From: Zoe Toppin <Zoe.Toppin@arun.gov.uk>
Sent: 04 May 2021 10:43
To: Planning.Responses <Planning.Responses@arun.gov.uk>
Subject: FW: EP/16/21/PL

EXISTING

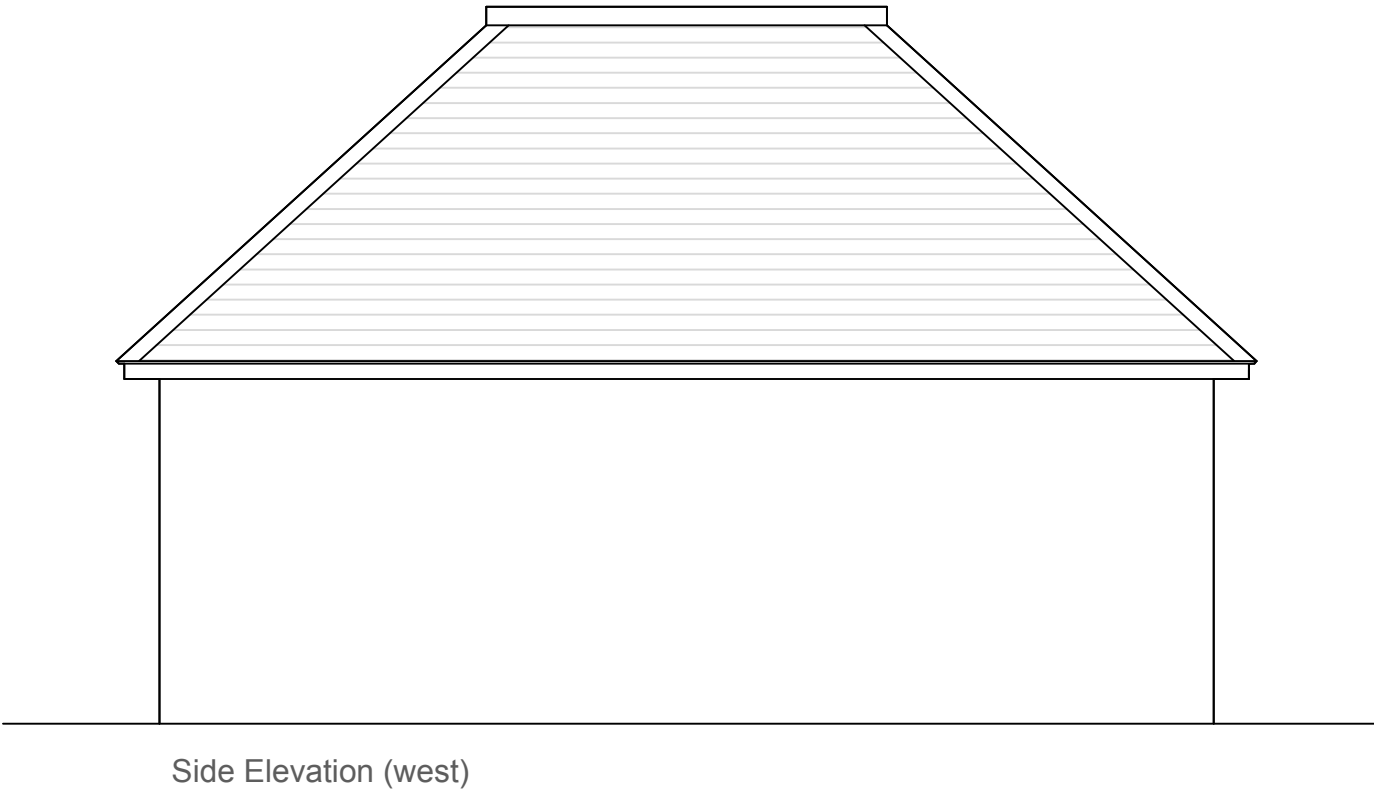
There has been a condition added to this application to show the three windows on the side (east) elevation of the garage will be permanently obscurely glazed and fixed shut up to a height of 1.7m from the finished floor level in order to protect the private amenity to the neighbours at the east. Please can you provide a plan to show this with a cross section from the ground to 1.7m to show the windows will be obscurely glazed and fixed shut up to a height of 1.7m.

There has also been concerns of why a dormer would be necessary for a garage if it is to be used as storage. As a result, it would be necessary to remove the dormer to the garage for this proposal. Please provide amended plans to show the dormer has been removed.

The three windows on west elevation should also be removed from the proposal as the garage will be used for storage there is no necessary need for windows, this will also create amenity issues.

1. An amended plan for the east elevation to show the cross section from the ground to 1.7m to show the windows will be obscurely glazed and fixed shut up to a height of 1.7m.
2. An amended plan to show the dormer has been removed.
3. An amended plan for the west elevation to show the three windows to be removed from the proposal

I have removed the dormer and reduced the number of roof lights. I have also reduced the size of the roof lights and positioned them so the cill of the roof lights are 1.7m from finished floor level so there is no overlooking. I have included a section to demonstrate the position of the roof lights.

I have reverted to a hipped roof at the rear of the building which is as per the pre-application advice scheme. I have done this in order to accommodate the staircase and still provide space for the two cars in the garage.
